North Carolina Department of Environment and Natural Resources  
Division of Waste Management

Re: Notice of Regulatory Requirements  
15A NCAC 2L .0405  
Risk-based Assessment and Corrective Action  
for Petroleum Underground Storage Tanks

**Vincent Peele Property**

**Parcel 105**  
111 W. 10<sup>th</sup> St., Greenville  
Pitt County  
Incident Number: **38380**  
Ranking: Undetermined

Exhibit 2 – Site Diagram with Soil Boring Locations and Analytical Data

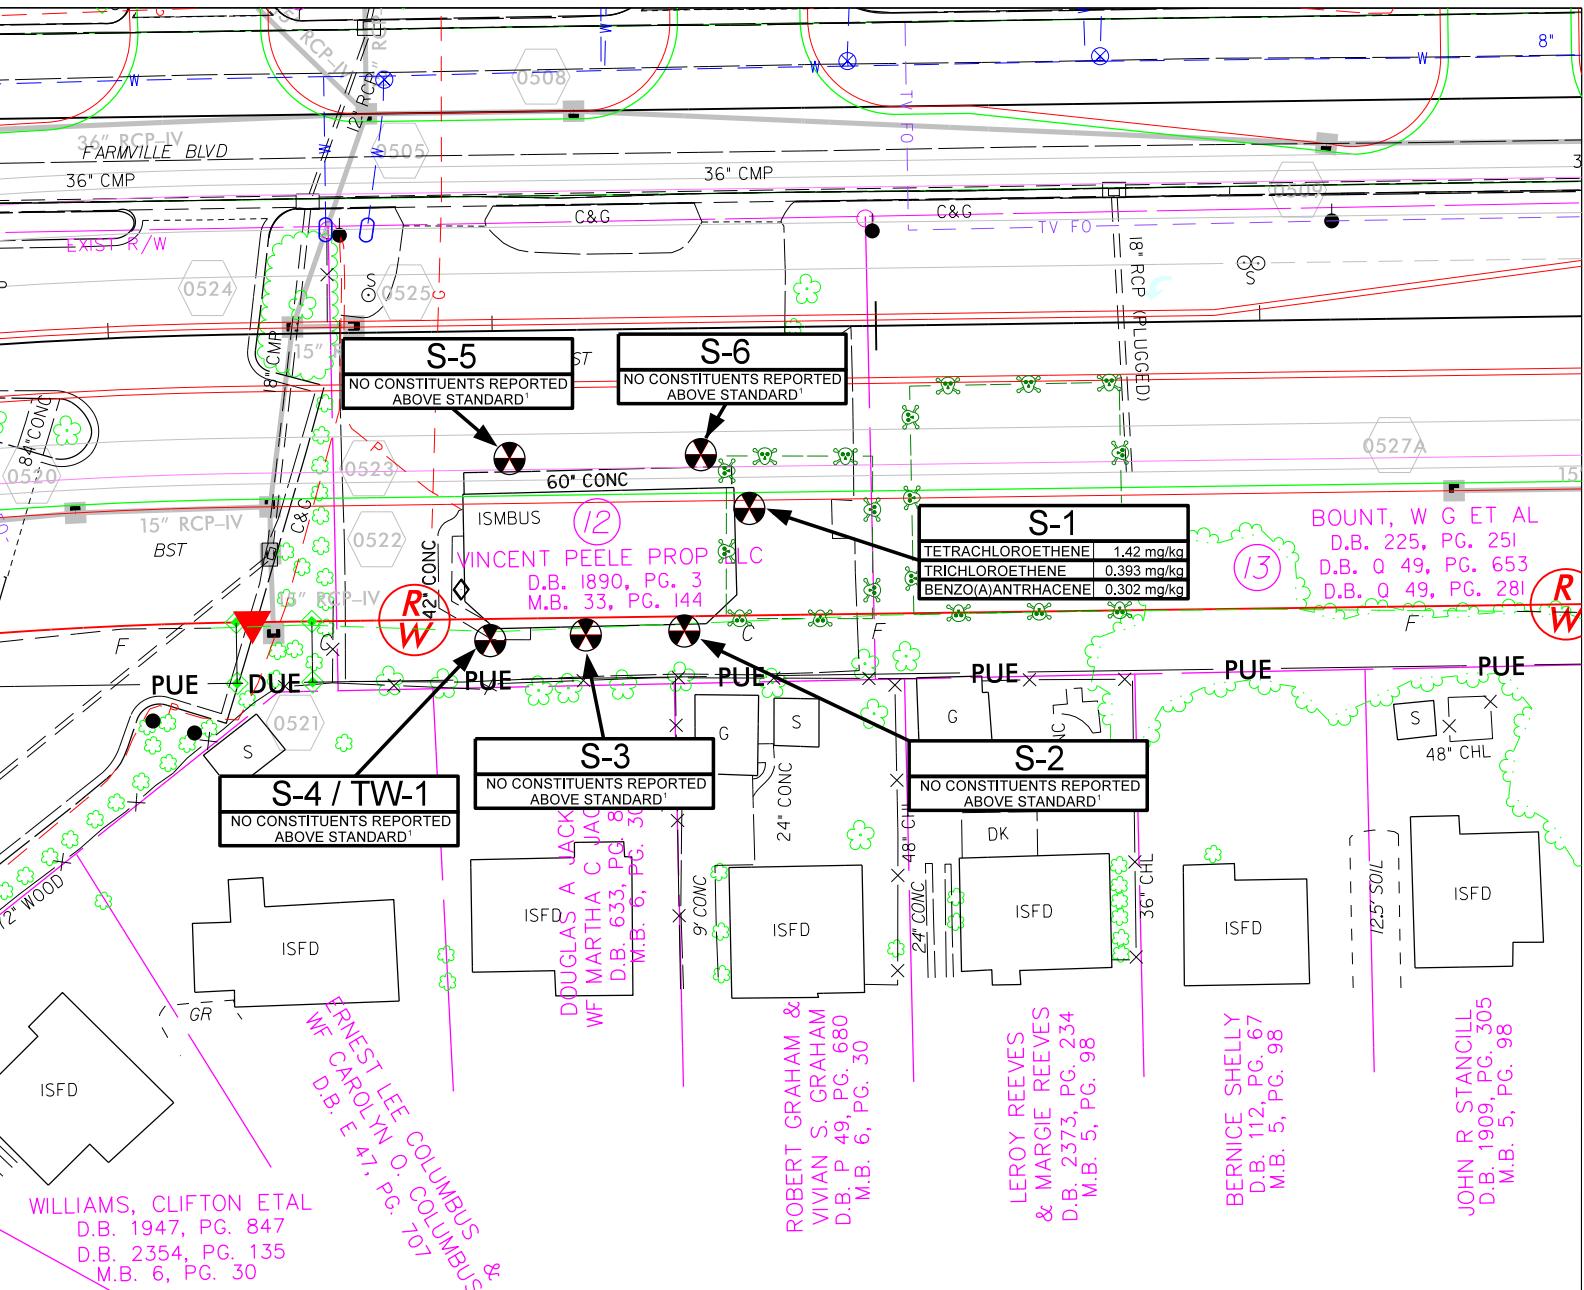
- Please submit a Limited Site Assessment (LSA) Report within 45 days of the date of this letter.
- In addition, please also collect a confirmation risk-based soil sample at soil boring location 105DPT-09. Analyze soil using MADEP EPH/VPH.
